2024/0427

Address: 48 Broomhead Road, Wombwell, Barnsley, S73 0SB

Description: Erection of 2 storey side and single storey rear extensions and install of block paving to front to replace existing lawn, to 2 storey semi-detached dwelling.

Recommendation: Refuse

PROPOSED GROUND FLOOR PLAN - SCALE 1:50

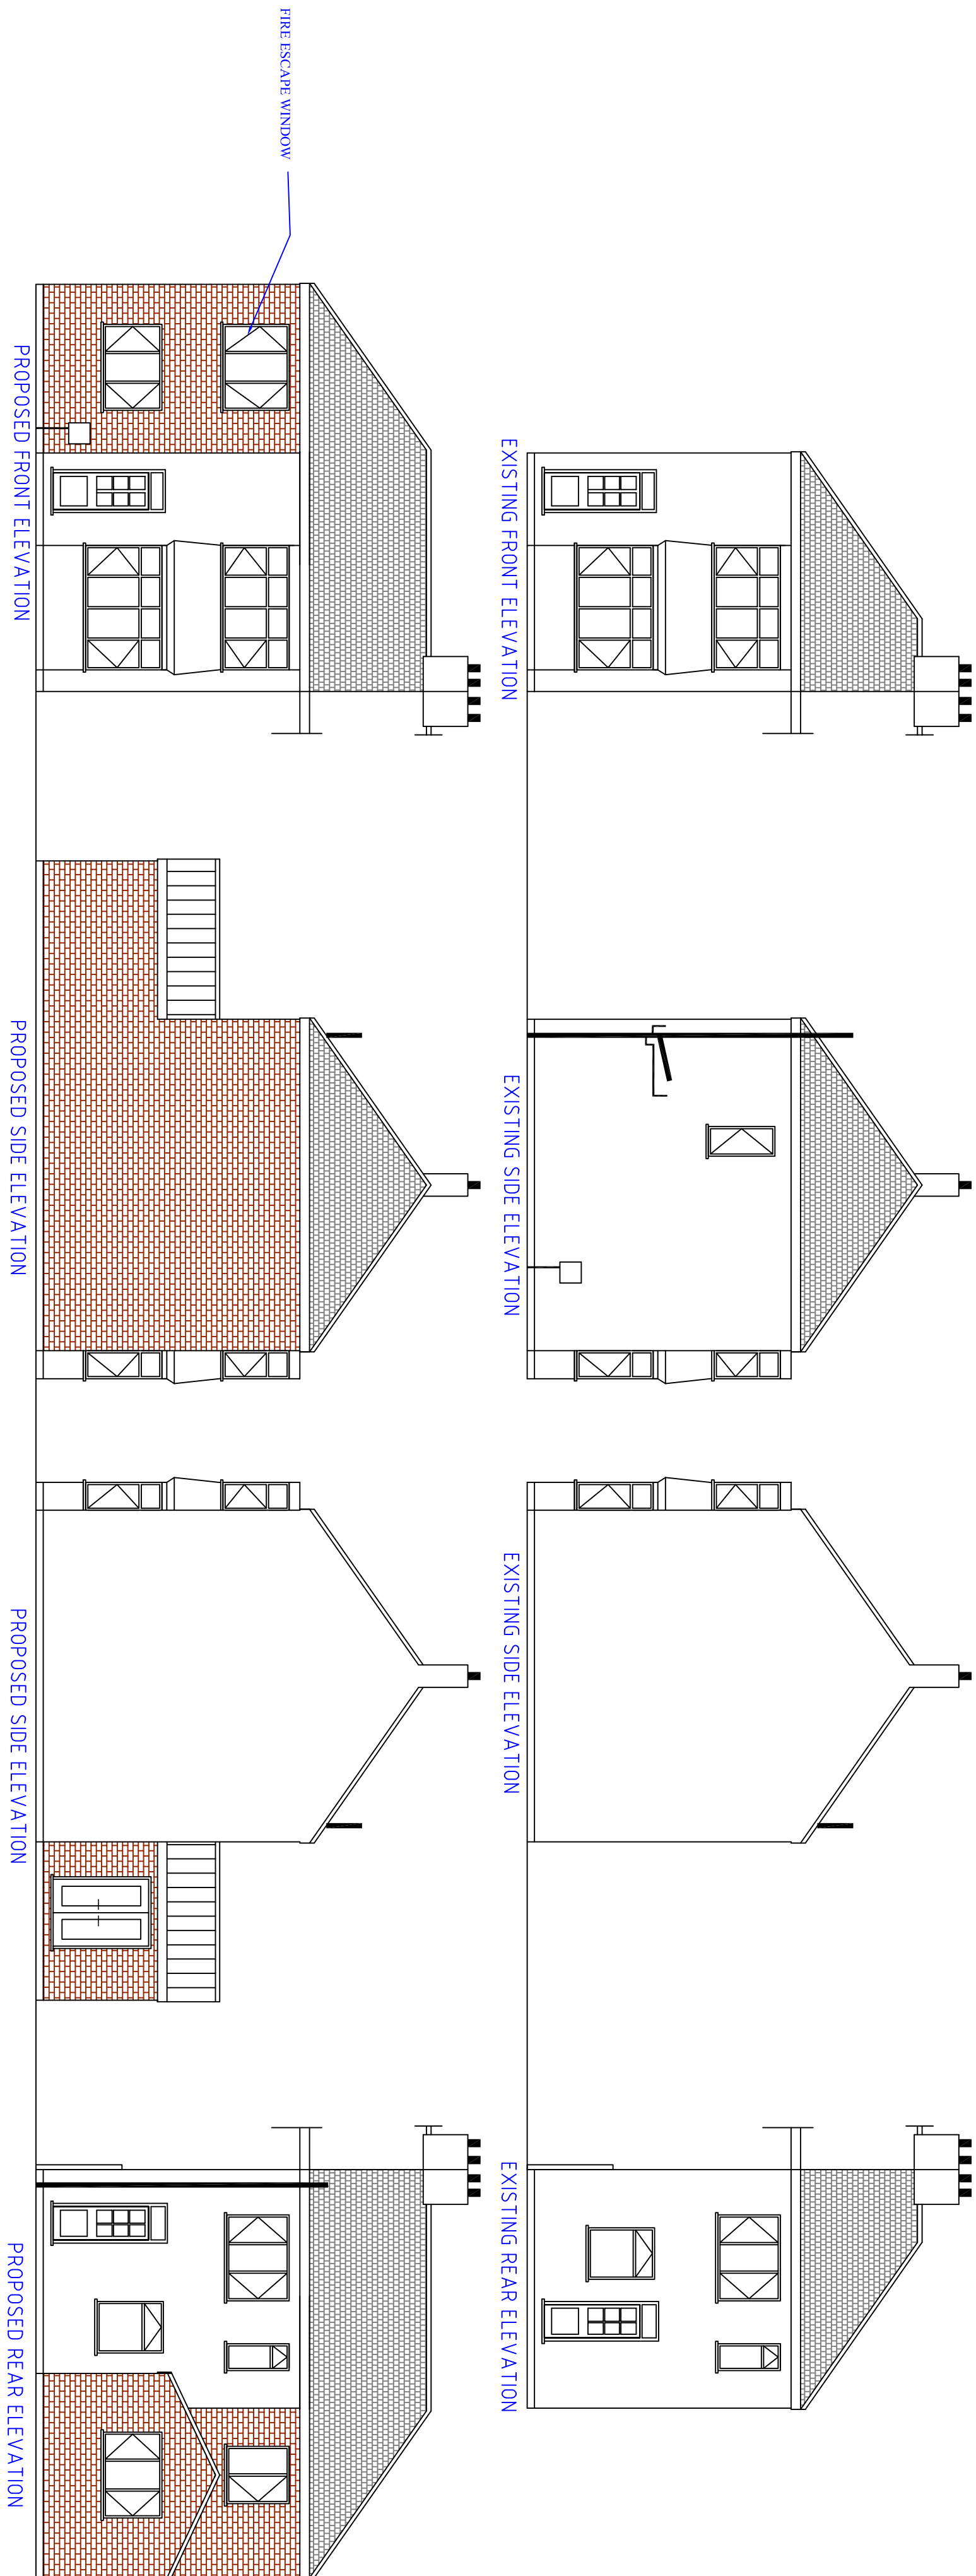
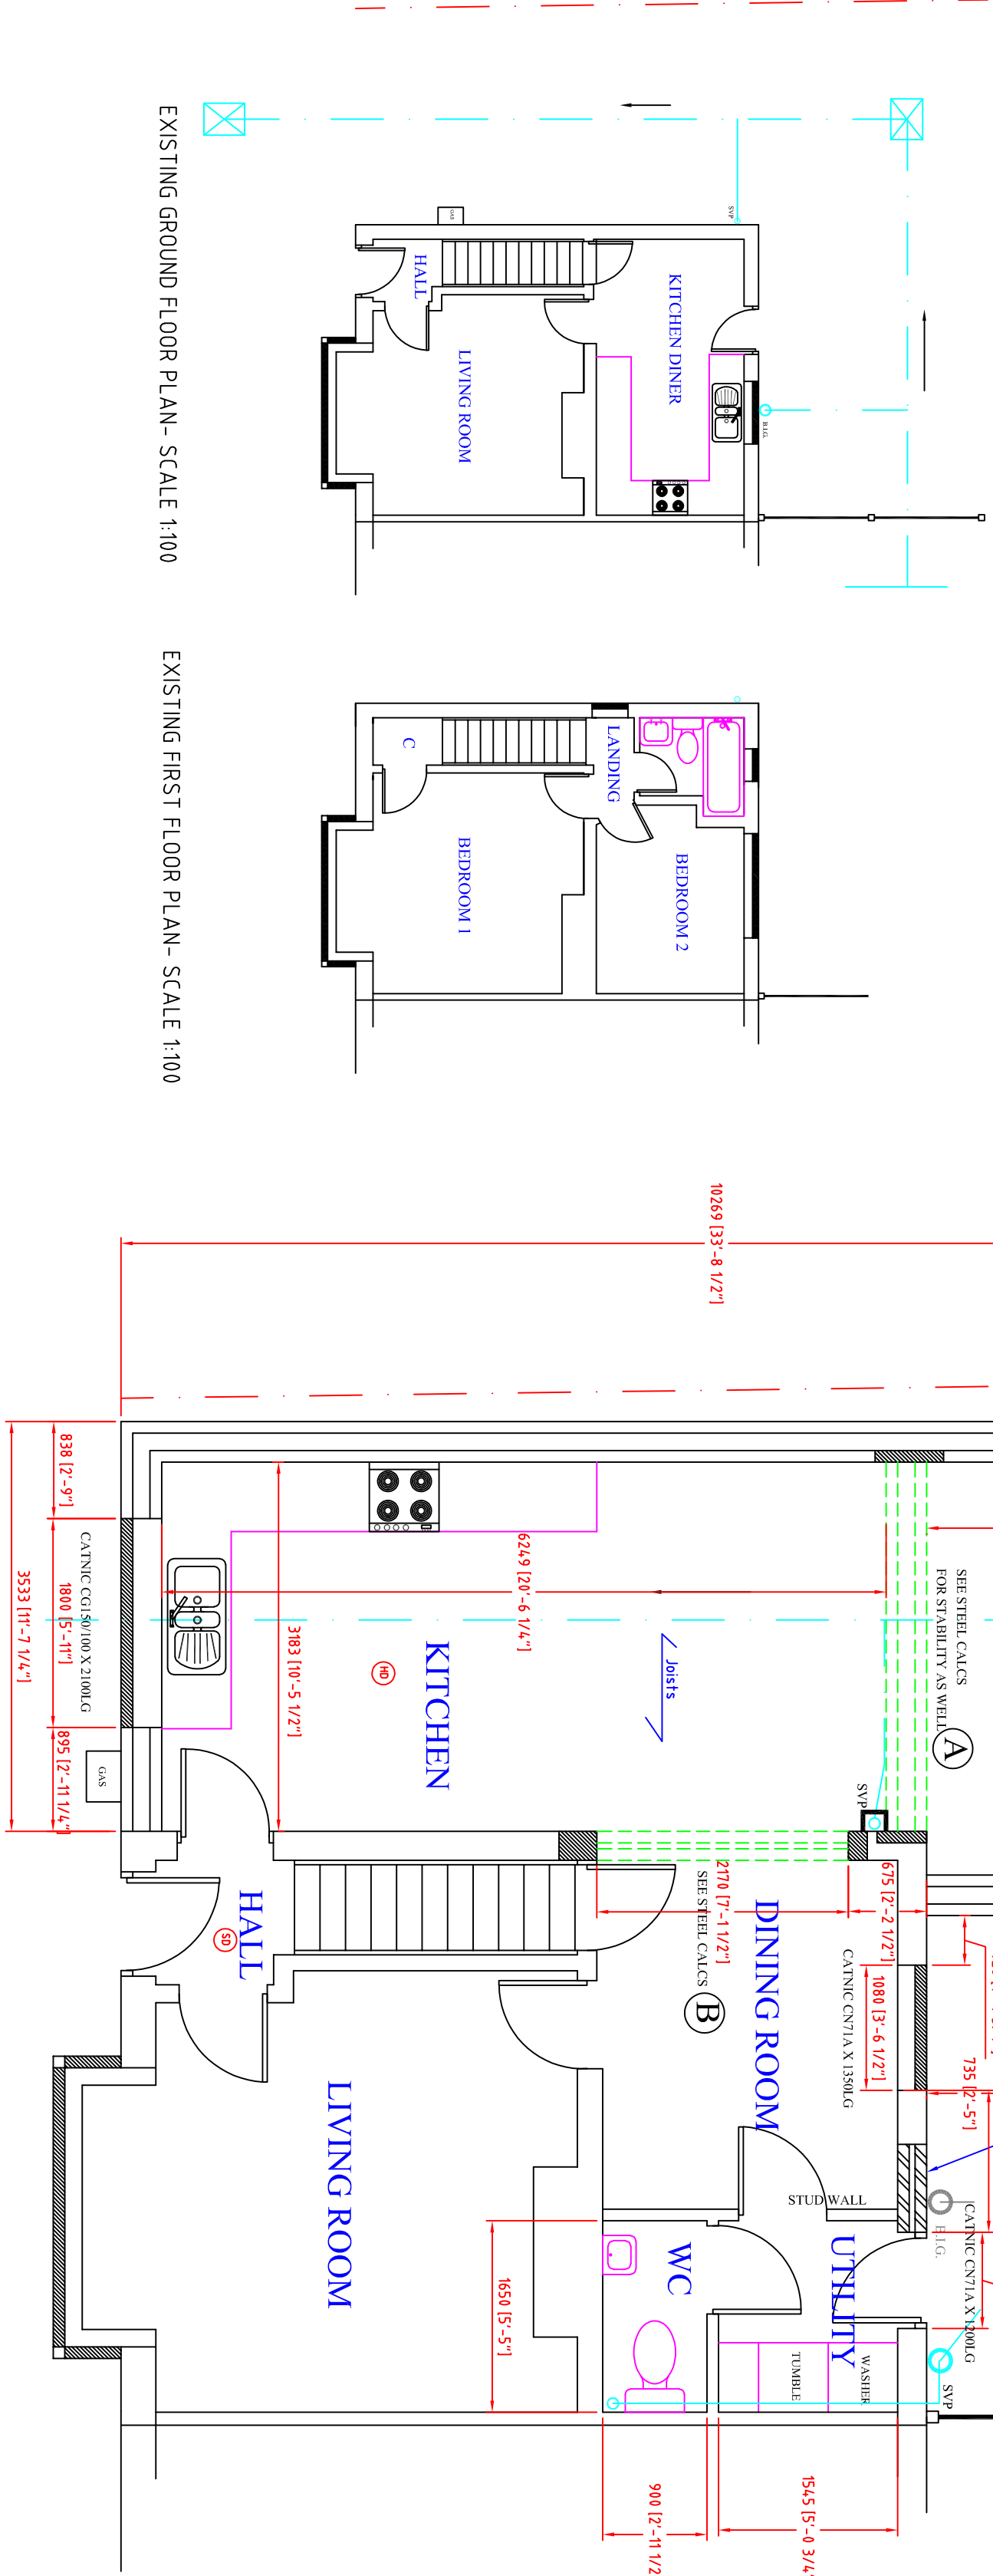
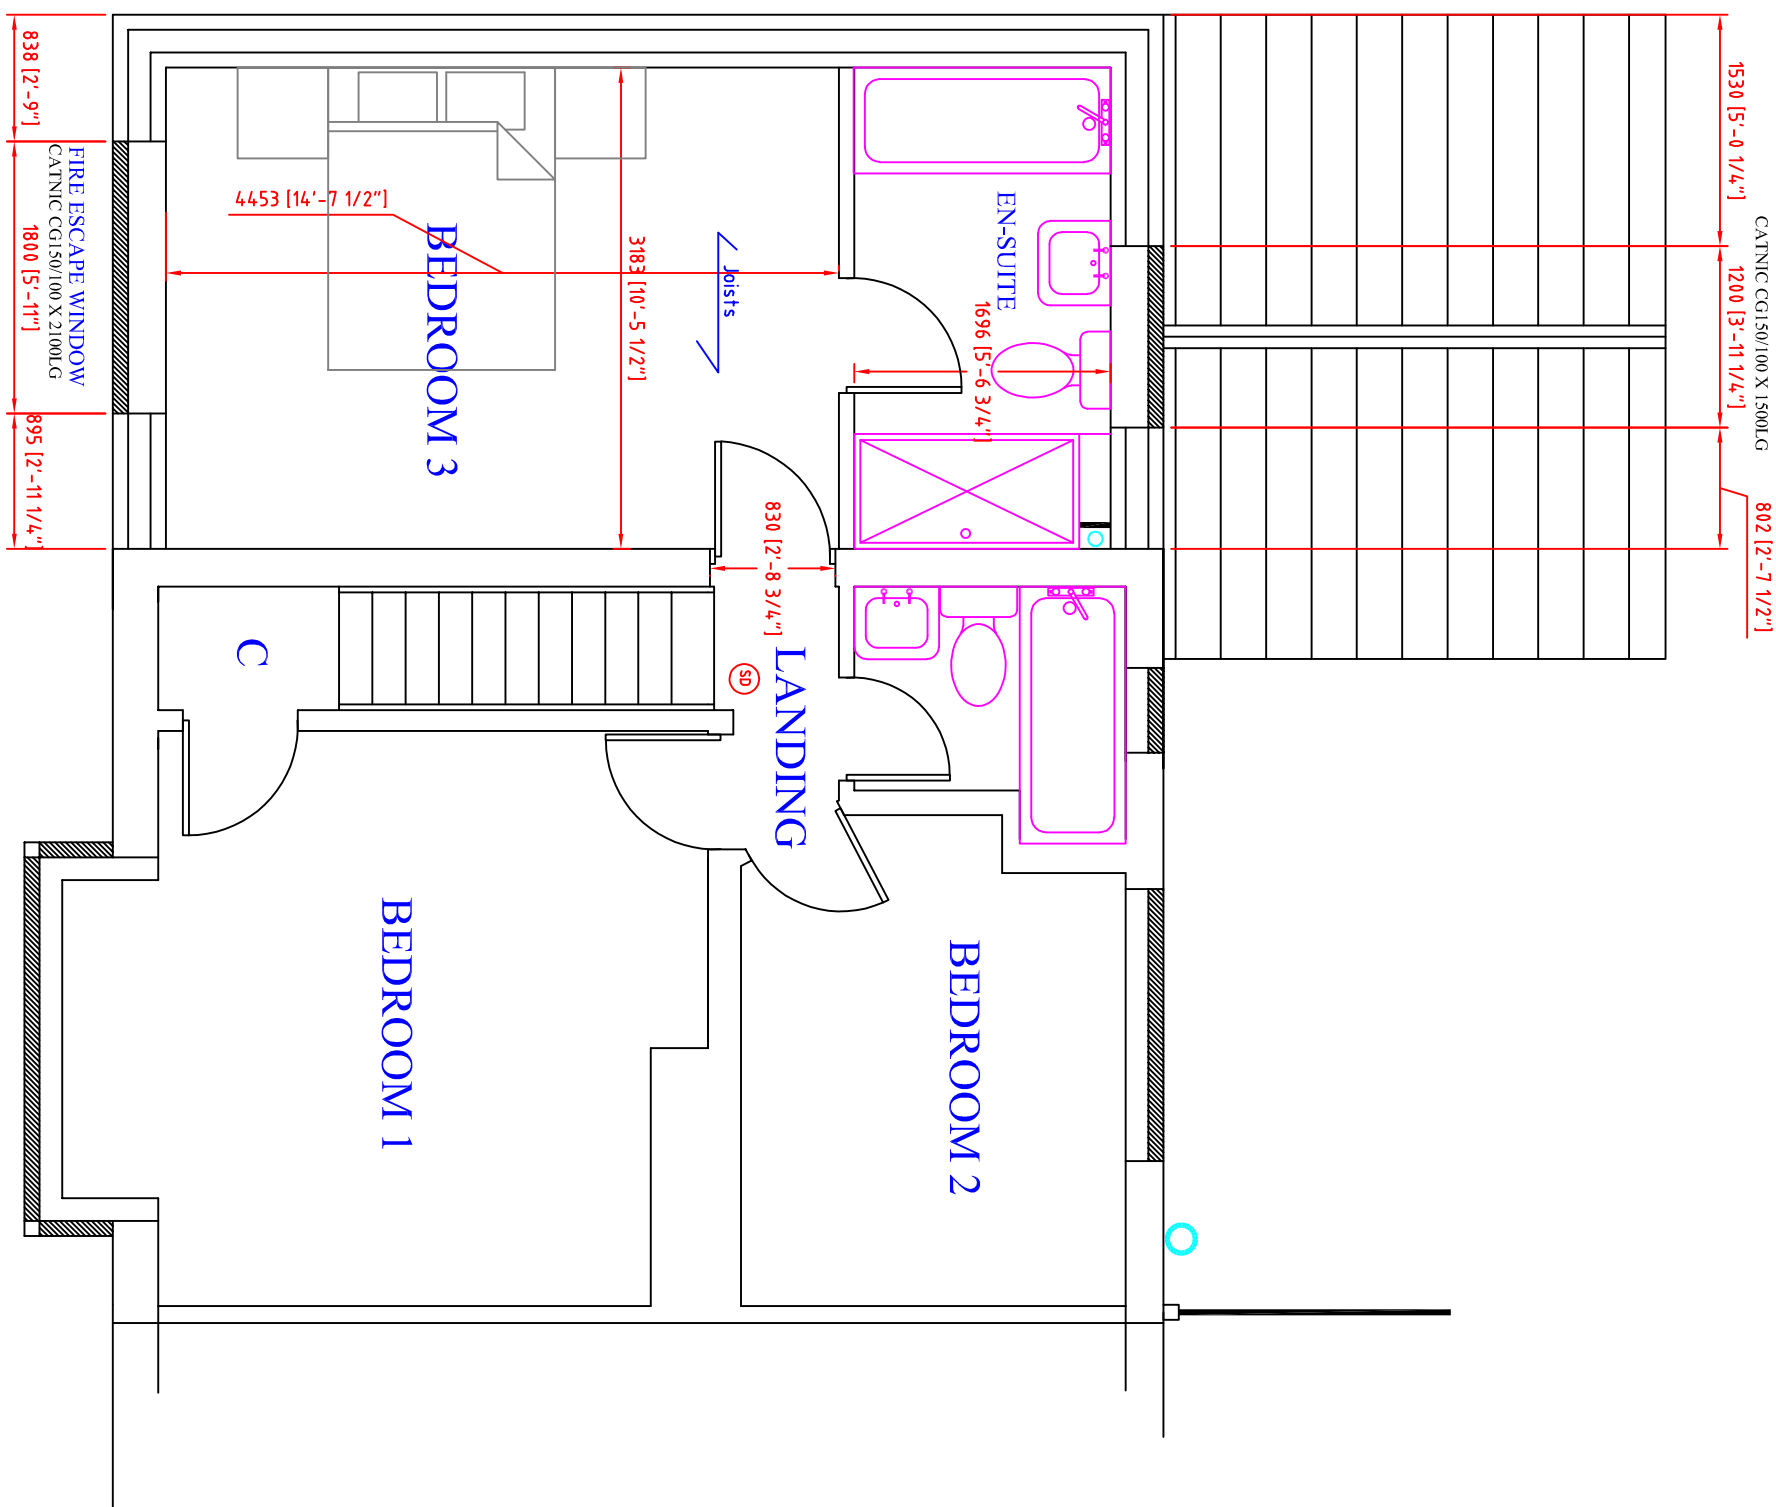
Broomhead Road is a long, almost straight road but in some areas, small cul-de-sacs intersect the street, as in this instance which creates corner plots such as the application dwelling, with its rear garden backing onto the front gardens of dwellings to the rear. This unusual positioning of the dwelling within the broader street scene does raise some concerns about overshadowing and loss of outlook caused by the proposed two-story side extension, although the rear ground floor extension would have less impact. Whilst light levels should not be significantly affected, there would be a potential loss of outlook for some dwellings within the rear cul-de-sac caused by the height and width of the side extension. Because of the width of the extension, being very close to the highway (pavement), there may be a negative effect overshadowing on pedestrian access into the cul-de-sac with a sense of overbearing. Although currently there is an extension at No. 60, if the proposal at the application dwelling was allowed, a precedent would be set causing difficulty to refuse any similar extension being constructed at No. 60. If extensions were allowed at both dwellings, the combined impact would have a more severe impact than potential impact caused by the current proposal at the application dwelling. Together, similar extensions would create a tunnel effect leading into the estate, cause a greater detriment to pedestrians and have a substantial impact on overshadowing and loss of outlook within the cul-de-sac.

Regarding privacy, both the front and rear first floor elevation windows of the side extension would be of an acceptable distance to of over 21m to directly overlooked windows of neighboring dwellings, but the rear windows would closely overlook several front gardens of dwellings to the rear, in comparison to the greater distances between the front windows and gardens across the road. For the attached neighbour of No.46, there would be no impact from the side extension and minimal impact from the rear ground floor extension as the neighbouring dwelling have their own rear extension. In common, there would be minimal impact on the amenity of the adjacent corner plot at No.60.

Unlike residential amenity, which overall would have a moderate effect on current residential amenity of neighbouring dwellings, the issue of visual amenity is more complex as the proposal does not meet local policy requirements in two key aspects, and would have an immediate and significant impact upon visual amenity. Firstly, the proposals clearly do not meet the guidance of the local SPD House Extensions and Other Domestic Extensions, as there is no step down from the roof or set back within the front elevation of the side extension.

In contrast to the proposed non-compliant nature of the first issue, the second issue regarding visual amenity has been deemed potentially harmful to both the character of the dwelling and more significantly its impact within the broader street scene. In paragraph 7.25, page 19 of the local SPD

'House Extensions and Other Domestic Extensions' explicitly states that 'The sideways projection of a two-storey side extension should not exceed more than two thirds the width of the original dwelling. Where located on a corner plot the sideways projection should not exceed more than half the width of the gap between the side elevation of the original dwellings and the side boundary (unless the gap exceeded more than two thirds the width of the original dwelling).' On this occasion, on full assessment of the proposal, it was found that the proposal would breach this SPD requirement, and subsequently cause significant harm to the visual amenity of the street scene. Unlike No. 27, the opposite dwelling, which has a two-storey side extension, the space between the side elevation and the boundary treatment of the application dwelling is of much shorter width than was originally available at No. 27 and could be comparable to the residual width between the extension and boundary of No.27. Once this issue was confirmed, an option to reduce the size of the proposal, particularly the width of the two-story side extension was offered, prior to making a refusal of the application, but ultimately this was deemed unacceptable, and a refusal of the application was requested.
